Revised October 27, 2020
March 5, 2020

Re: OWTS – Site Evaluation
7765 Electronic Drive
El Paso County, Colorado

TEST PIT LOCATION MAP
 7765 ELECTRONIC DRIVE
 EL PASO COUNTY, COLORADO
 FOR: DAVID STEFANO

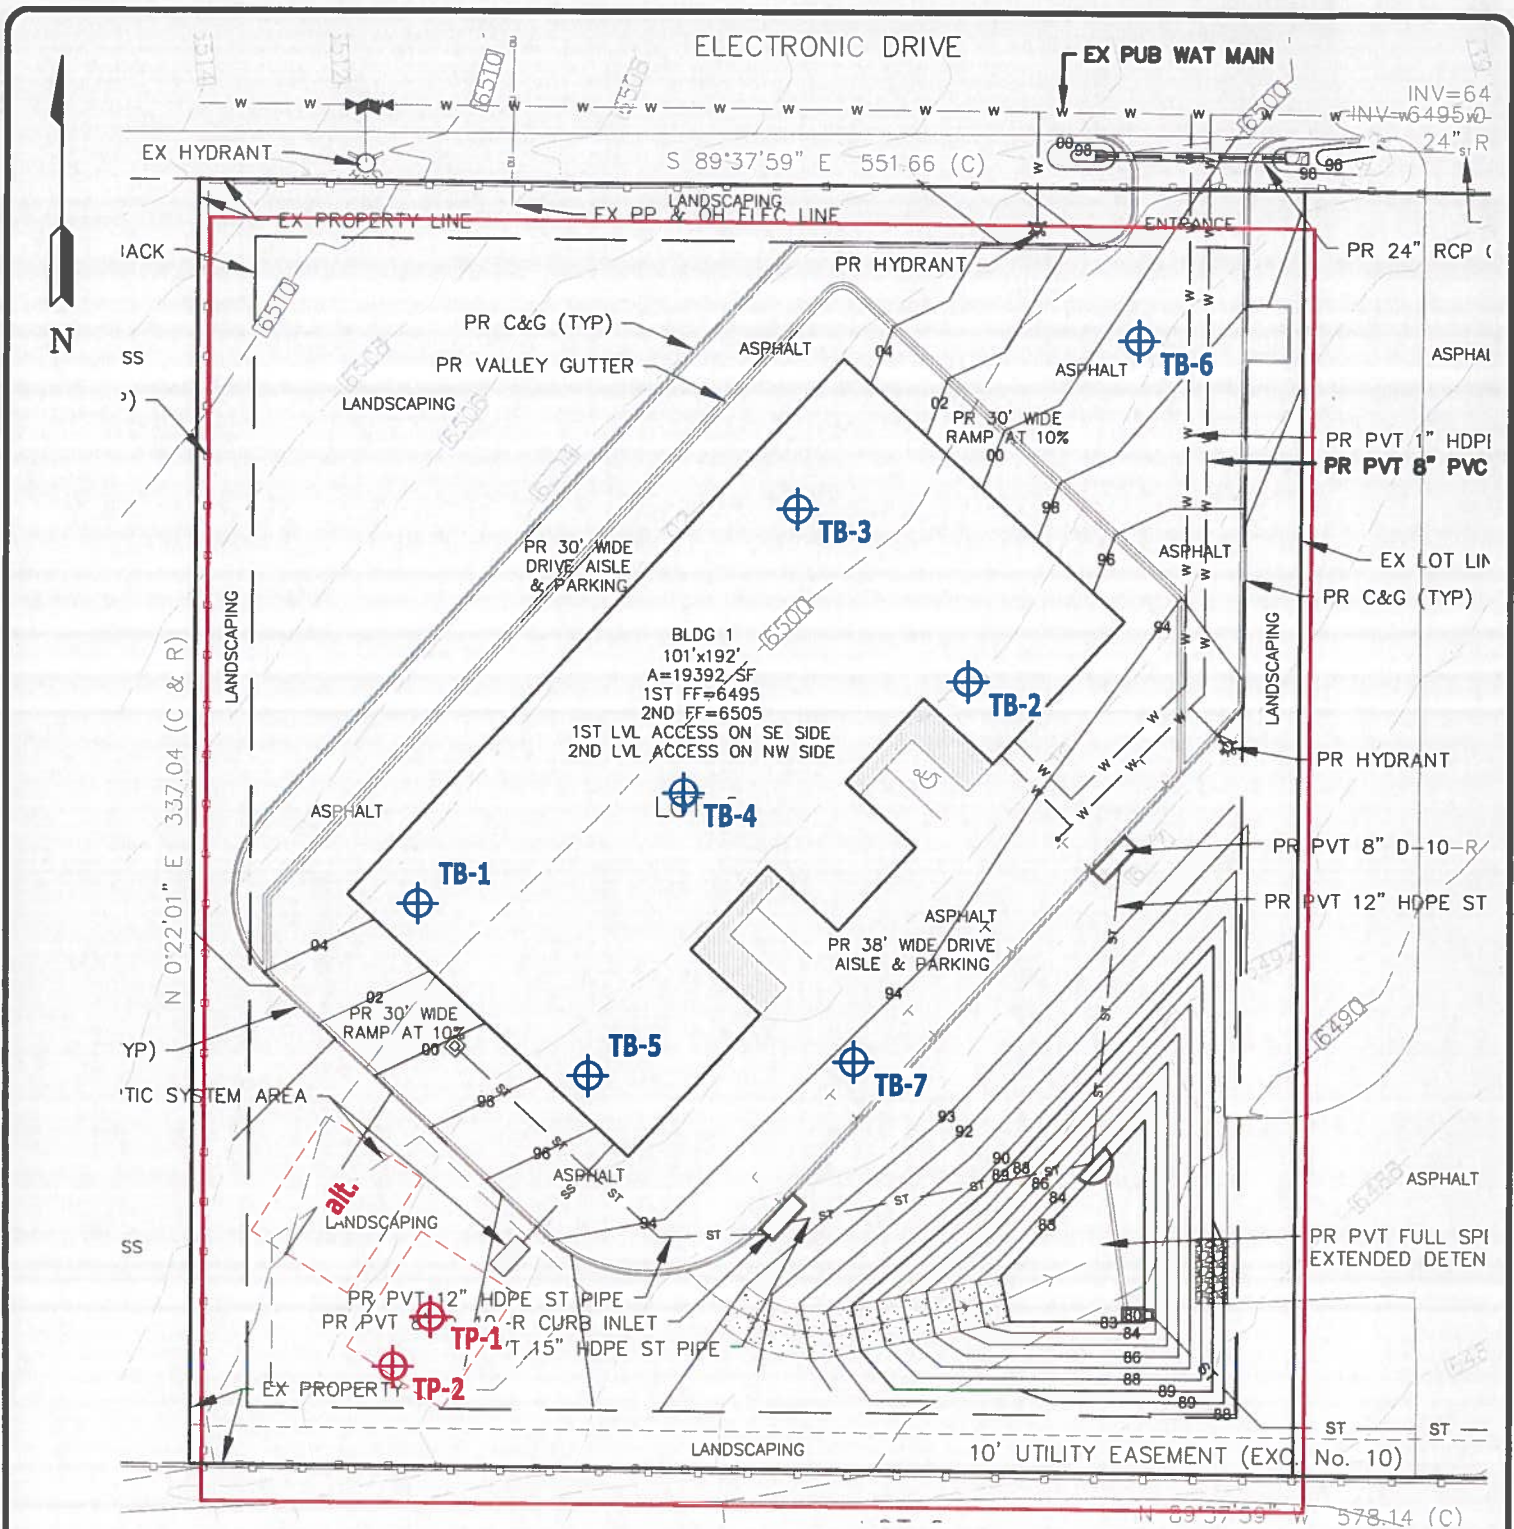
Map showing a minimum of 2 potential septic system locations has still not been provided. Revise and resubmit with potential sites identified
